Appeal Decision

Appeal Ref: APP/R5510/D/24/3342689

15 Roker Park Avenue, Ickenham, Middlesex UB10 8ED

- The appeal is made under section 78 of the Town and Country Planning Act 1990 (as amended) against a refusal to grant planning permission.
- The appeal is made by Mrs R Cheema against the decision of the Council of the London Borough of Hillingdon.
- The application Ref is 41735/APP/2023/3496.
- The development proposed is the erection of a first-floor side extension.

Drawing Number:  
2373-PL-102

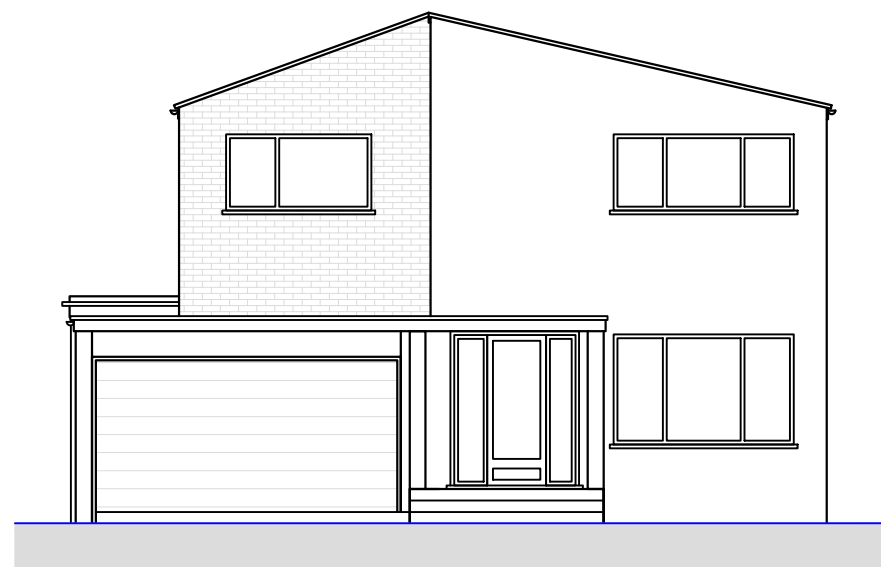
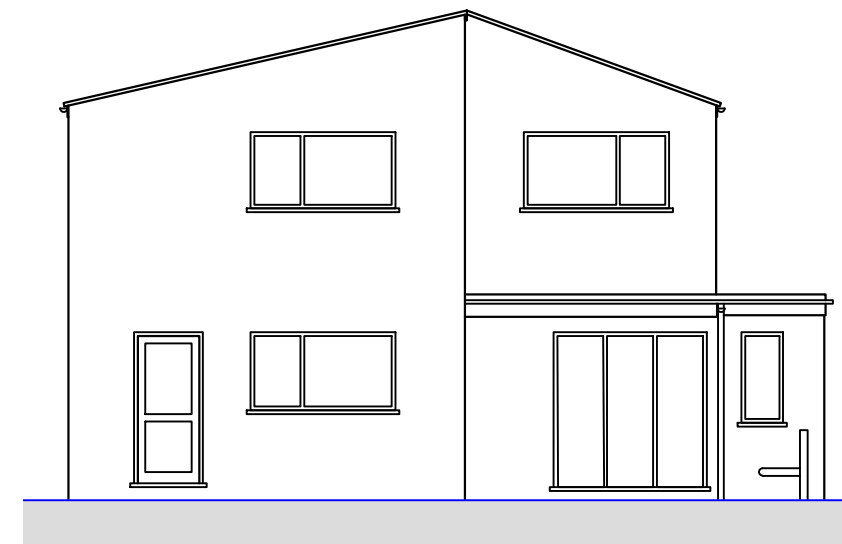
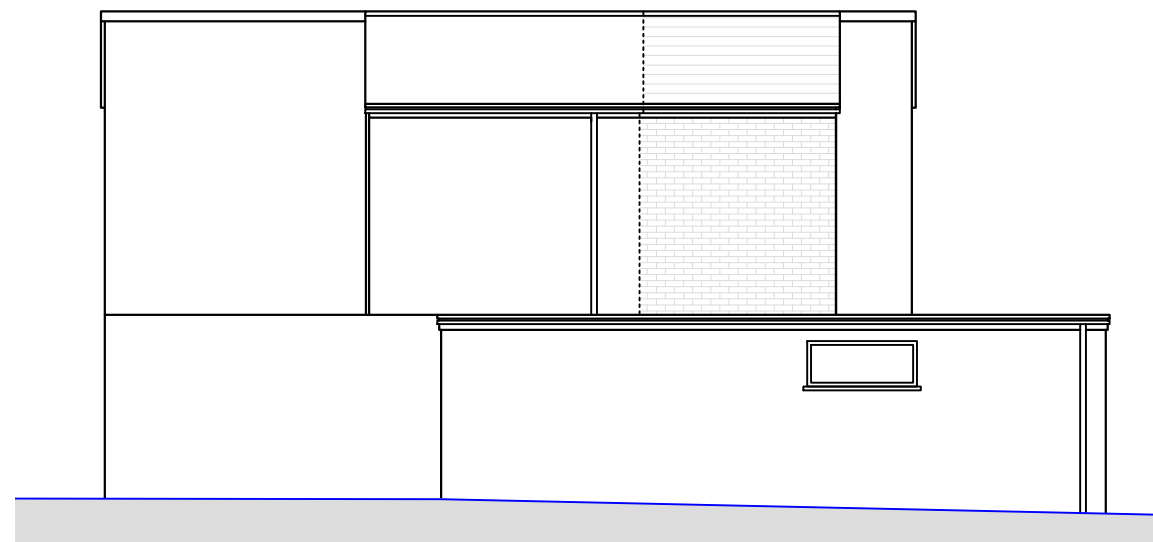
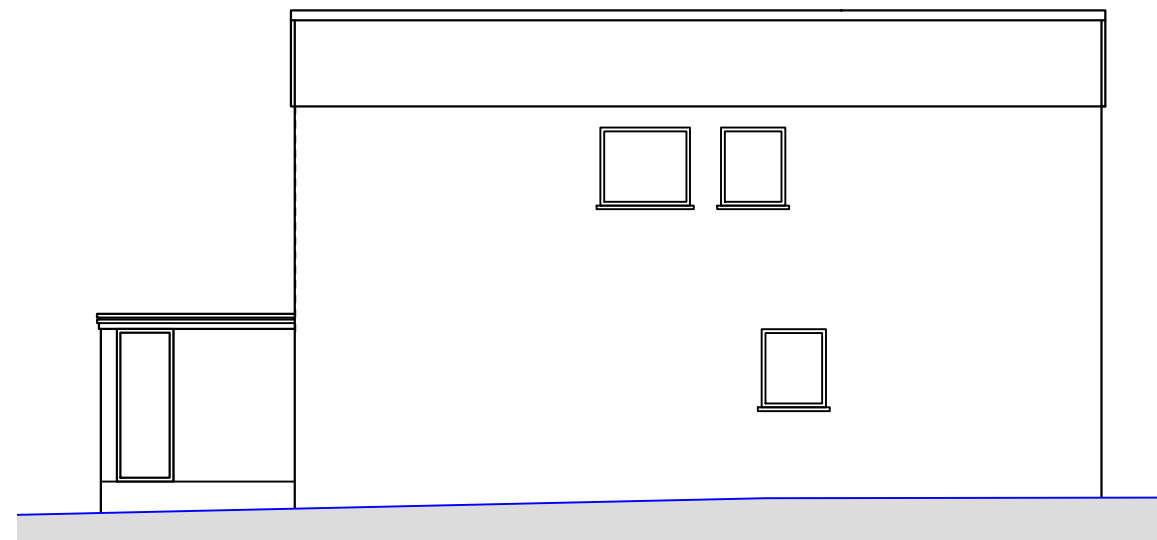
6. Whilst the appeal proposal includes this 1 metre set back, the introduction of a first-floor extension in this location would fail to harmonise with the original architectural composition of the host dwelling. The resultant building would be markedly at odds with the prevailing style of houses in the road, which is so

typical of Roker Park Avenue. This is particularly the case as it would result in the substantial loss of the distinctive stepped front elevation which is a key design feature of these contemporary properties. It would also result in the loss of the tall vertical side window which is another key design feature. As a result, the proposal would unacceptably erode the uniformed quality of the area.
